April 16, 2021

Add PCD Project #  
AL 21-015

RE: Venetucci Farm / Traffic Generation and Impact Analysis  
El Paso County, Colorado

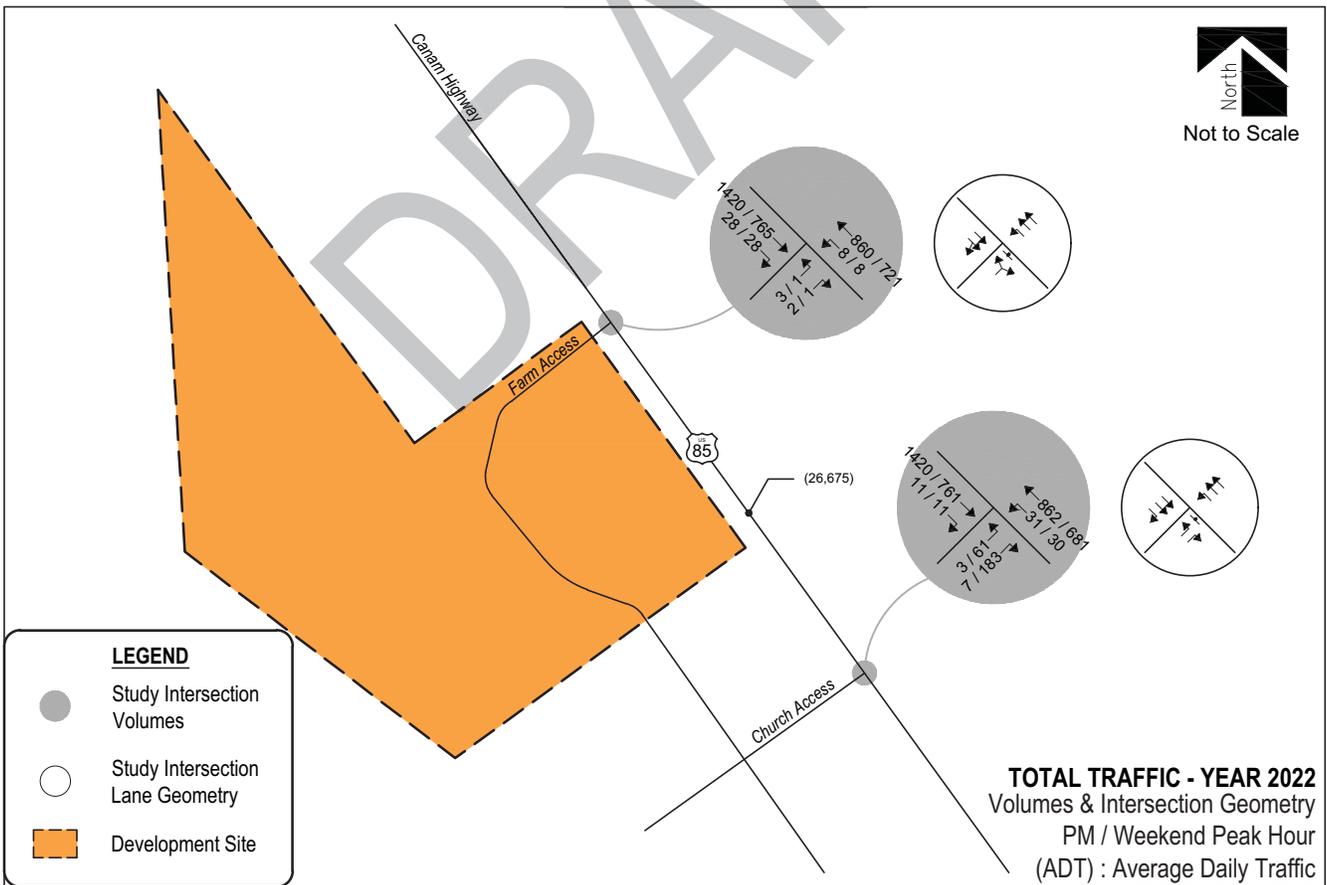
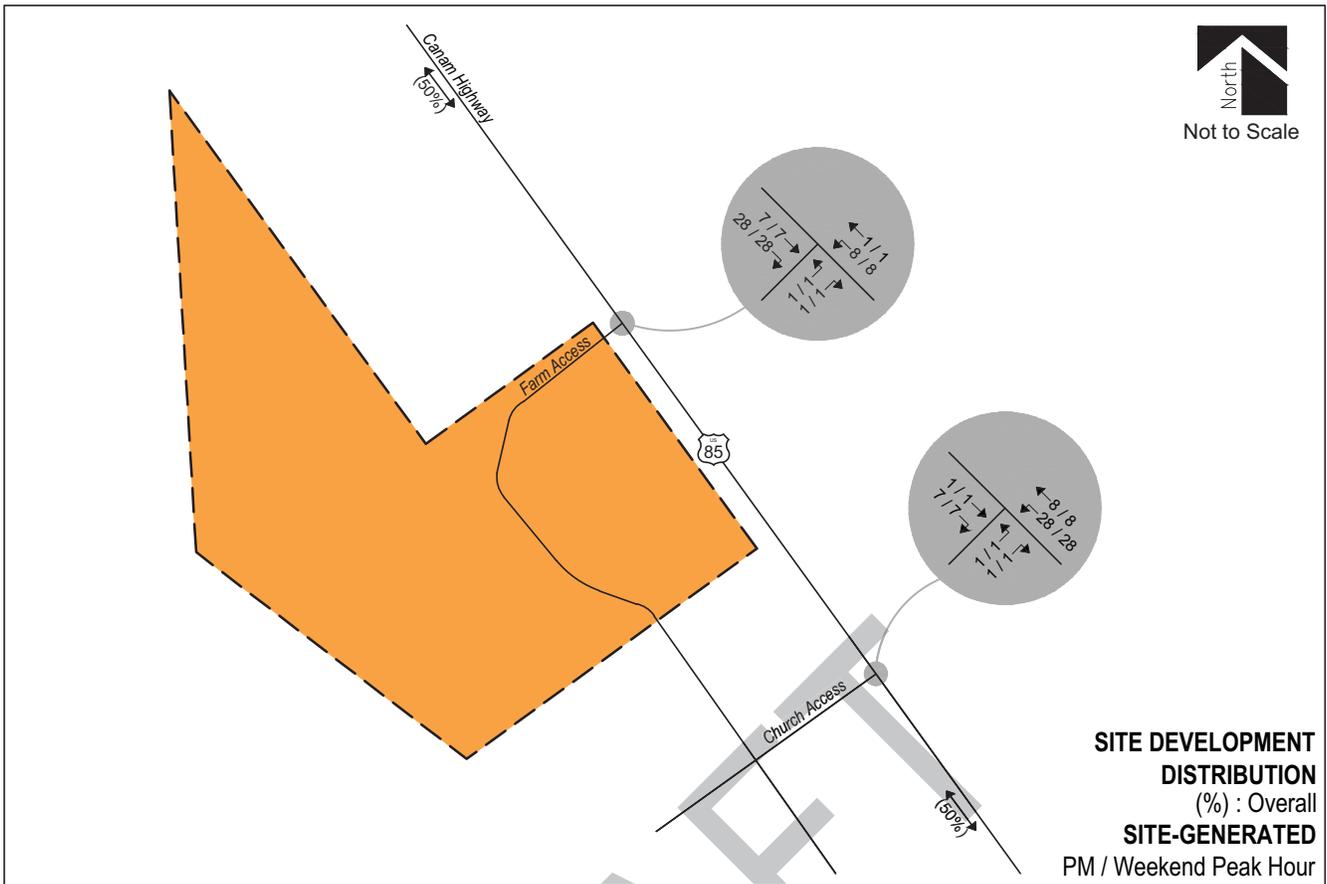
Discuss traffic impacts in the event the wedding venue occurs at the same time as church services on Sundays. It seems a worse-case scenario is having both church service and guest for the wedding venue arriving at the same time.
